Our Reference: SYD22/00426/01
DPE Reference: SSD-32489140

**EXHIBITION OF ENVIRONMENT IMPACT STATEMENT (EIS) (SSD-32489140)
ASCENT LOGISTICS CENTRE, 520-530 GARDENERS ROAD, ALEXANDRIA**

Thank you for referring the exhibition of the EIS to Transport for NSW (TfNSW) for review and comment. The agency has reviewed the EIS and request's that the Applicant addresses the below matters as part of the 'Response to Submissions' (RtS):

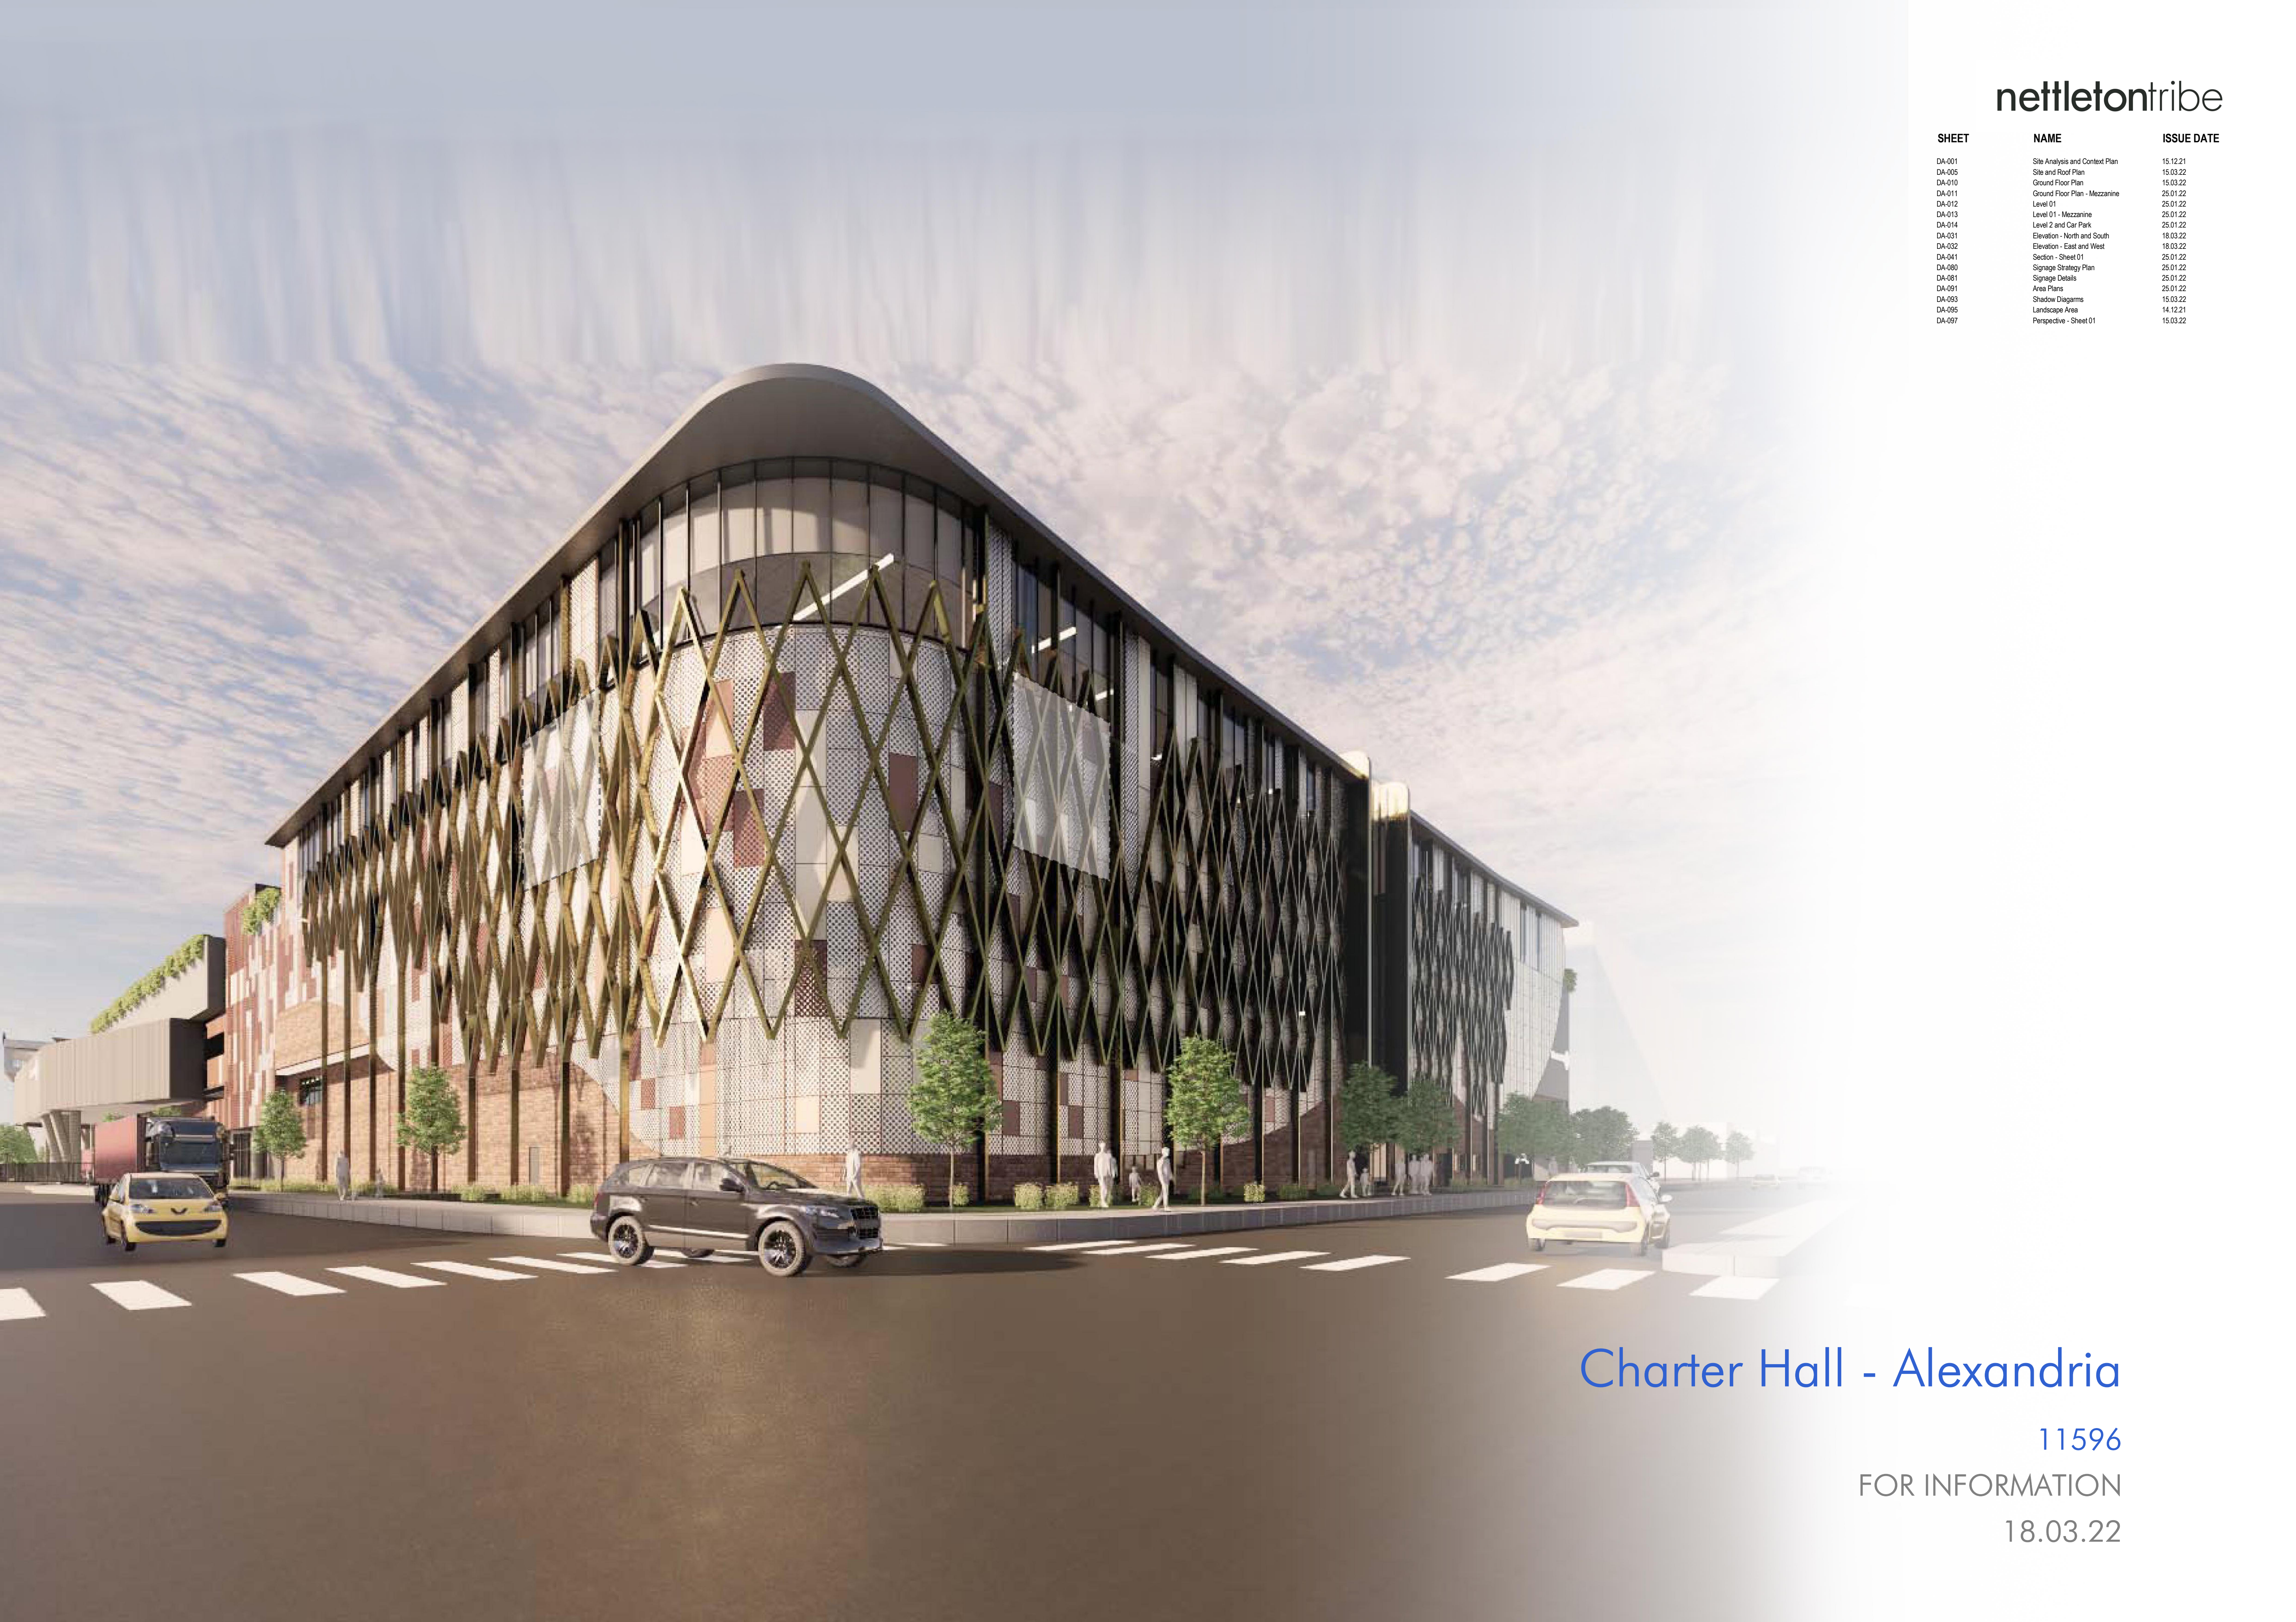
- The Gardeners Road access is currently traffic signal controlled that was installed based on generations of a previous development. The proposed generations to the subject site do not meet a Warrant Assessment for the traffic signals to be retained.

Rear -end crashes are the most common crash types occurring on Australian roads. Austroads research has demonstrated that close spaced traffic signals contribute to this accident type. The volumes generated are well below the Warrant Assessment and therefore the signals would be required to be removed and the median closed to restrict access to left-in, left-out (LILLO) arrangement. This work would be required to be undertaken by the Applicant at no cost to TfNSW and was previously communicated to the Applicant as part of pre-lodgement advice.

- As Gardeners Road is a classified road with high movement function, any disruptions to through traffic by slow moving service vehicles turning left accessing site could have a detrimental impact to network safety and efficiency but also operations to the future development's operations.
- Further to issue of rear end accidents, slow moving long vehicles turning left into the development would significantly disrupt the kerb side lane traffic flow and cause queuing and the potential to cause crashes near the existing intersection.

The impacts of this type of 'chaotic' event are difficult to realise from the analytical software tool used by the Applicant. As such, TfNSW recommends consideration is given to the development providing a left turn deceleration lane into the site from Gardeners Road in accordance with Australian Standards AS 2890.1 and Austroads Guide to Road Design: Part 4A: Un-signalised and Signalised Intersections (Section 3 – Sight Distance). Vegetation and proposed landscaping/fencing must not hinder sight lines to and from road users.

The agency notes that the proposed development's access arrangements has not adequately considered pedestrians and cyclists in the design.

The Applicant is to address the above matter as part of the RtS, including appropriate mitigation measures to the satisfaction of the agency.

The Applicant is to address the above matter as part of the RtS, including appropriate measures in the access arrangement design to support and encourage active transport.
